**Application: SSI 7485**

I write regarding the proposed modification to M4-M5 Link, Mod 2 The Crescent overpass and changes to pedestrian infrastructure in North Annandale, Rozelle and Rozelle Bay Foreshore area.

Figure 4-2 Pedestrian and cyclist bridge infrastructure options

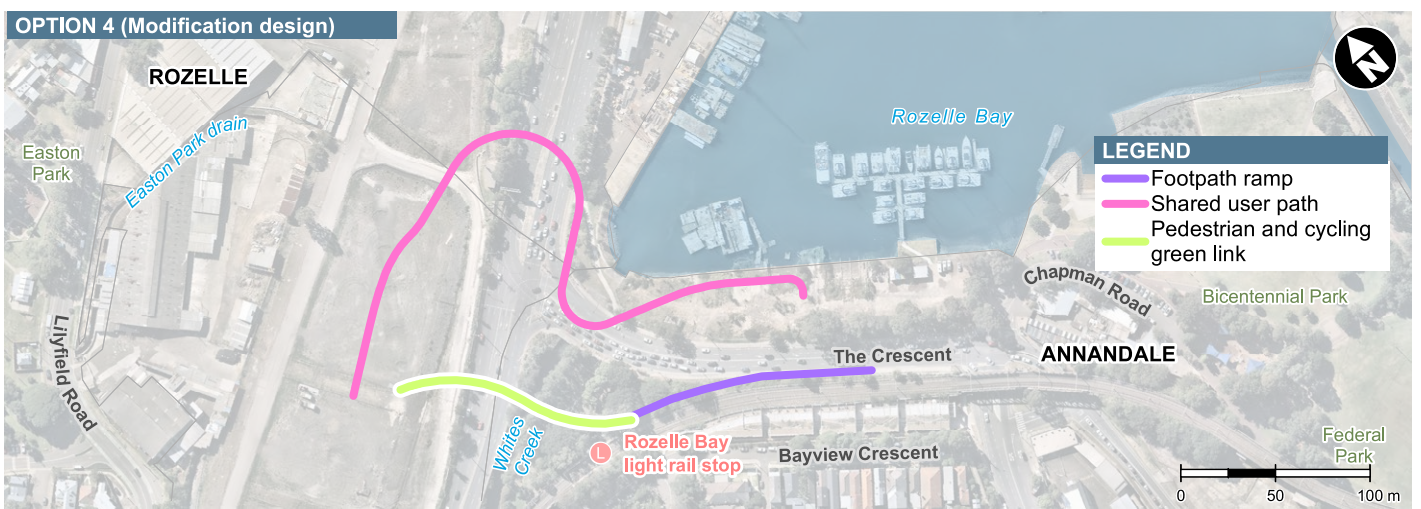
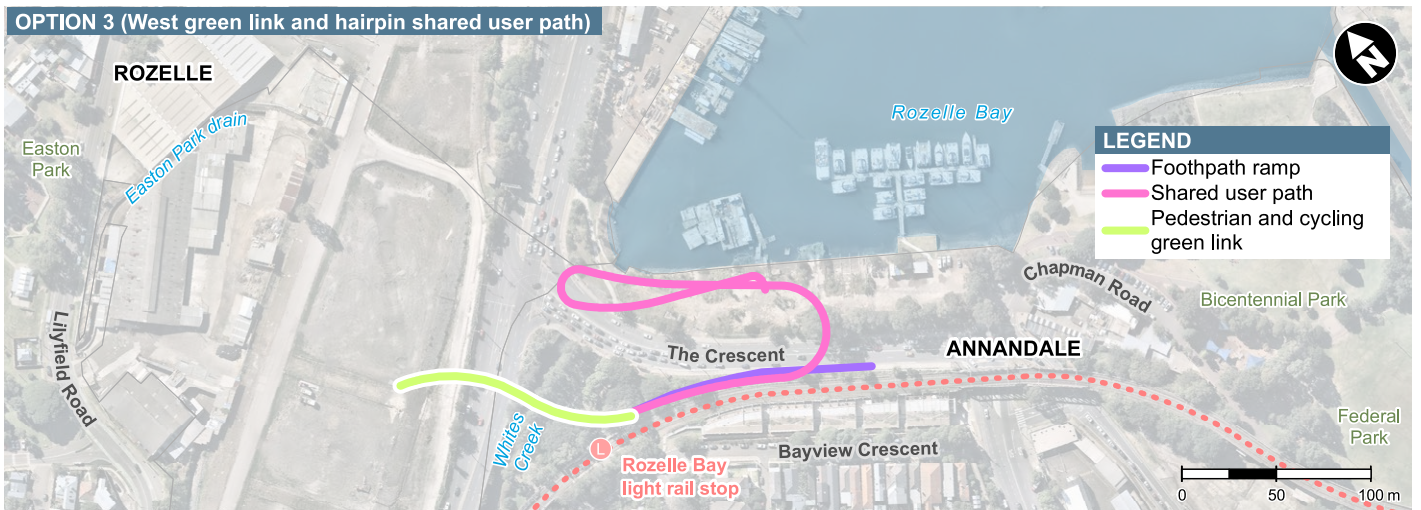
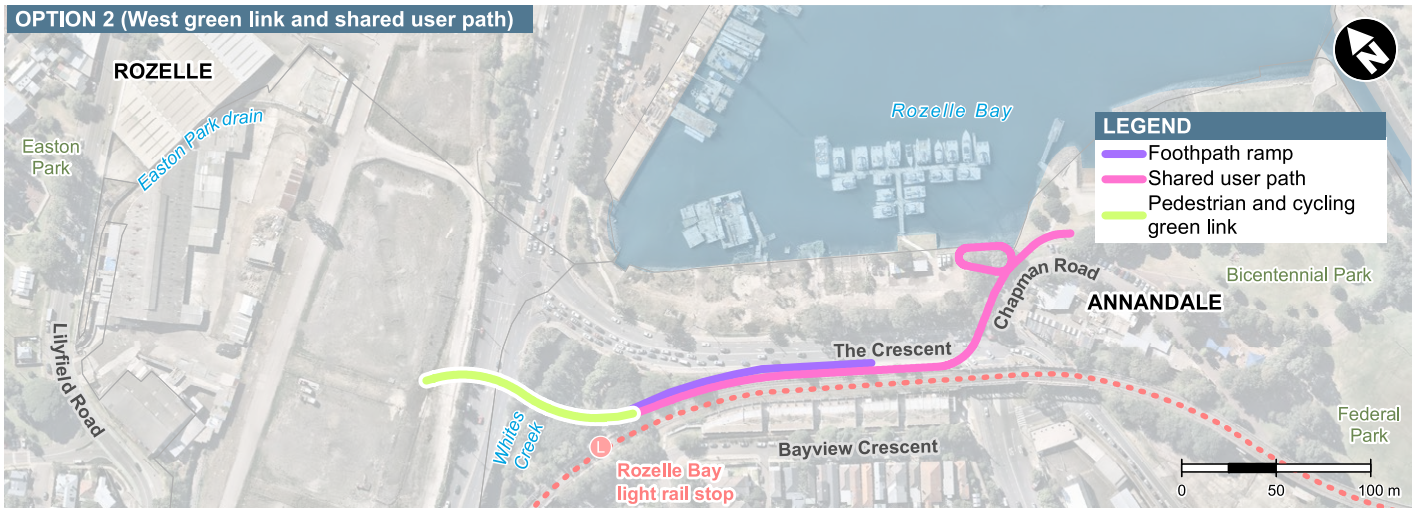
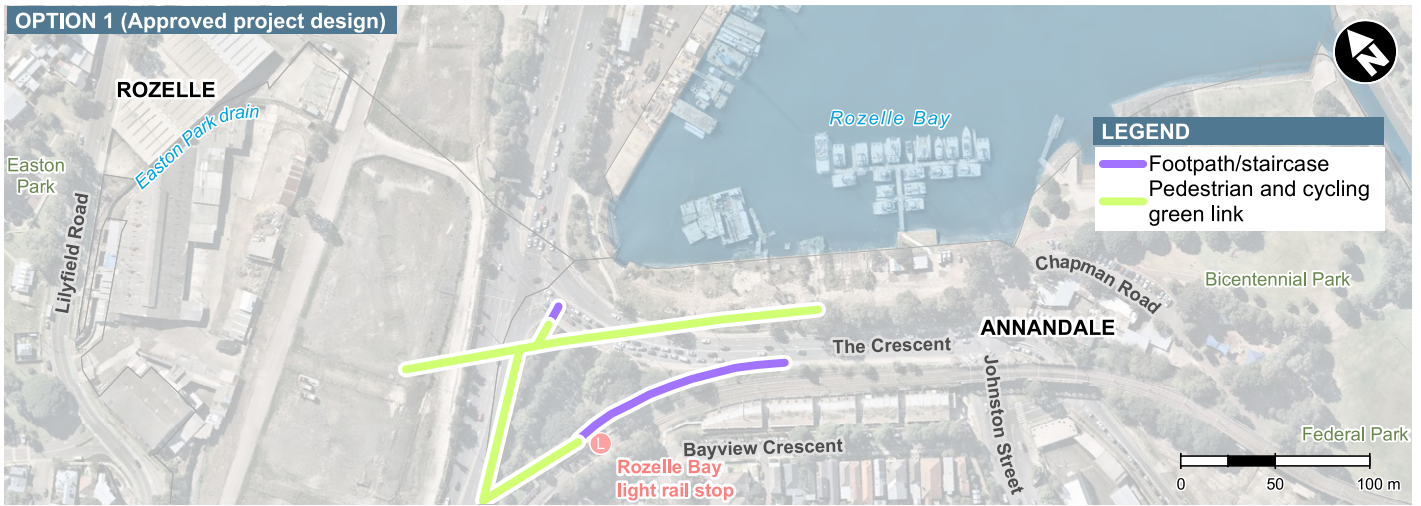
I request RMS work with the community to explore alternate design options to the proposed new car overpass design and the changed pedestrian and cyclist links. I am seeking the reinstatement of the safe, direct access from the approved EIS GreenLink to create a continuous green open space connection from the Rozelle Rail yards and Annandale to the foreshore. The GreenLink was more than just a walk way - it put people central to the design, maximising safety, and providing much needed accessible open space for the community now and into the future Bays Precinct design.

- The significantly reduced safety and increased risk for pedestrians and cyclists with removed access over The Crescent to Bicentennial Park and the increased traffic along Johnson Street.
- Being required to cross five sets of pedestrian lights at The Crescent as my option to reach the foreshore from Annandale or from Rozelle Bay light rail stop.
- Removal of direct active links to the foreshore, cutting the community off from the area and the proposed revitalisation of the entire Bays Precinct, including linking the Light Rail and Bus stops to a Ferry wharf and Metro station.
- Urban and landscape design that is being built before a finalised Masterplan for the area.
- Traffic changes that limit movements around the suburb and create further congestion in the local streets of Annandale, Forest Lodge, Glebe, Lilyfield and Rozelle with no planning to deal with these.

- Reinstate the GreenLink connecting communities and green open space from Rozelle to Bicentennial Park
- Relocate and design pedestrian and cyclist connections that are continuous, safe and direct.
- Design the modification infrastructure and active links in response to the character of the suburbs, the location of the foreshore and it's potential future development.
- Provide pedestrian and cyclist paths that maximise people safety and do not force them onto busier streets, unsafe concrete plazas and caged walkways.
- Integrate active and direct connections to all active transport - including the future Metro West and Foreshore Ferry Wharf

Figure 4-4 Elevation: Indicative view of The Crescent overpass

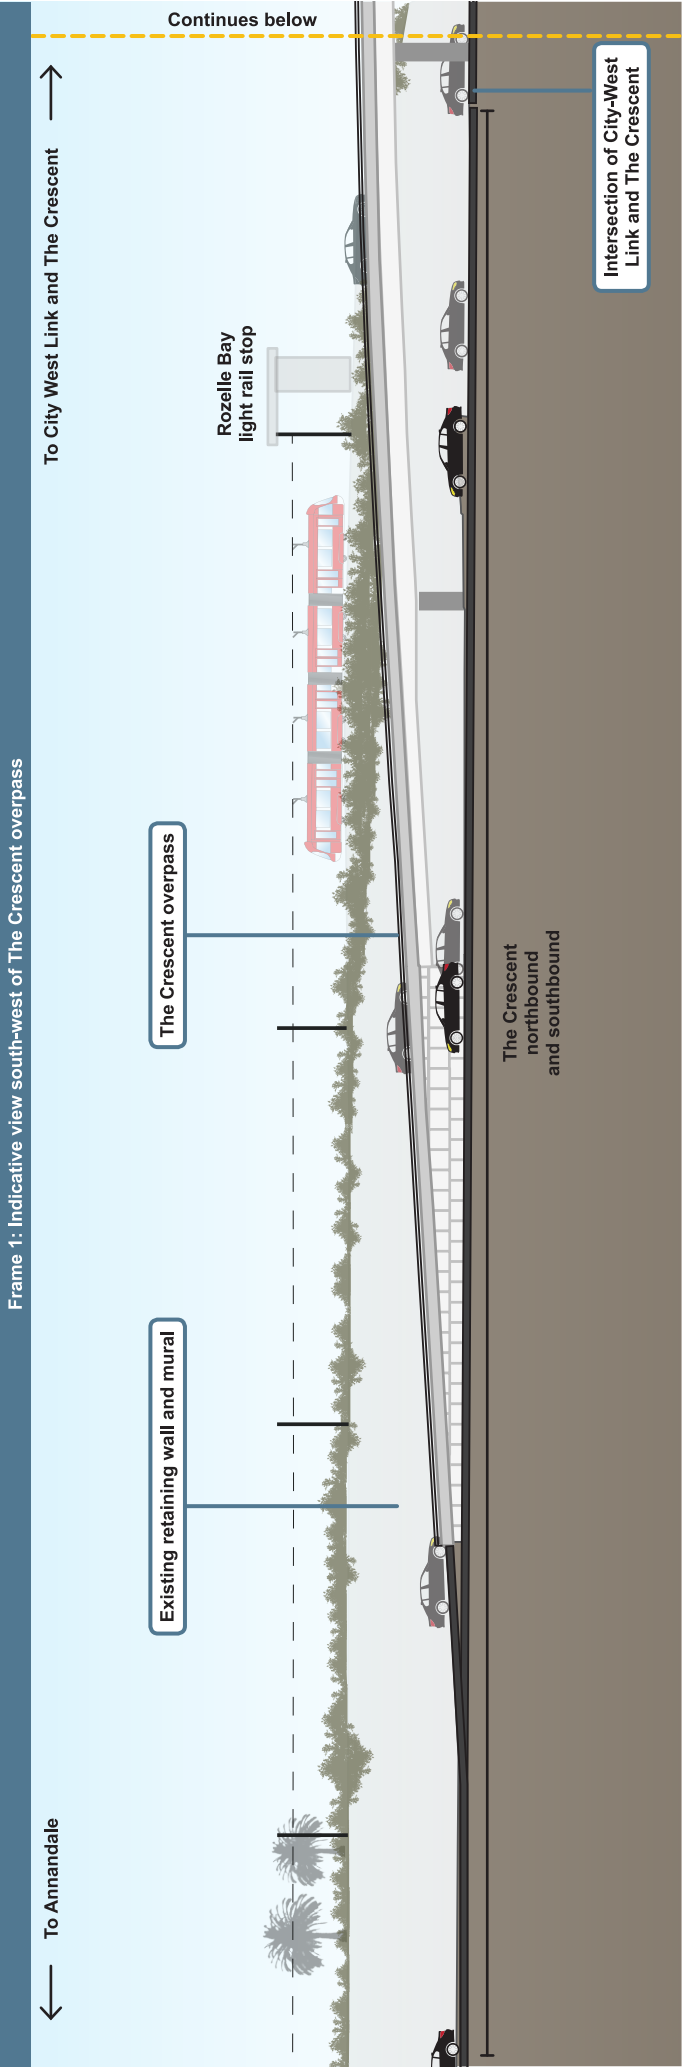
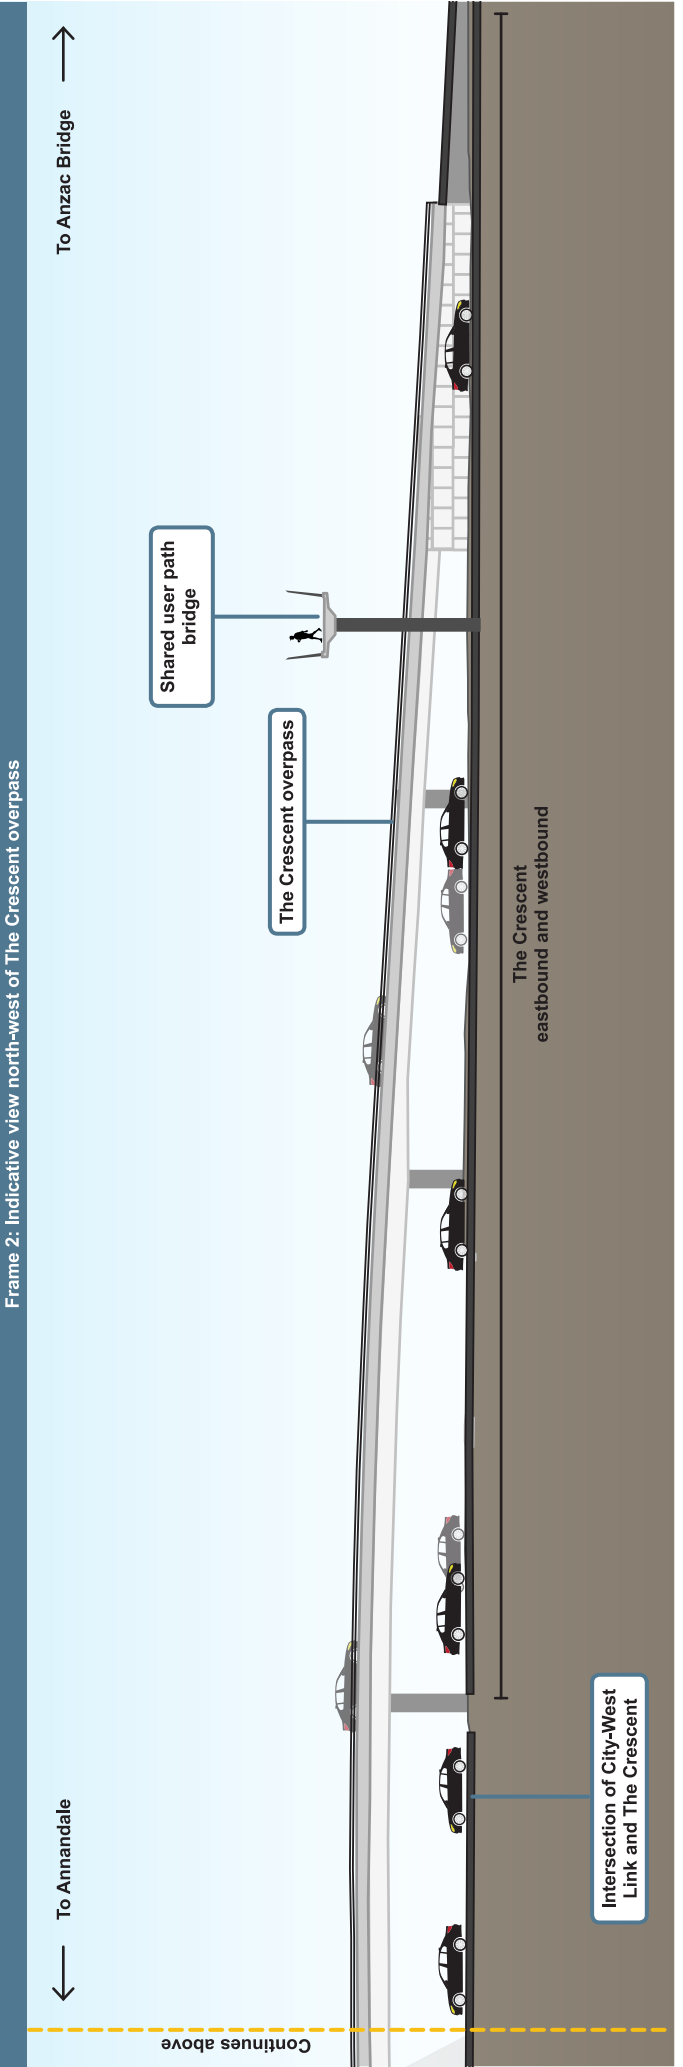
*The deception of being told this interchange would be underground. The project has already destroyed enough of the inner west without now leaving a horrible blight on the landscape of the planned Bays Precinct for decades to come.*
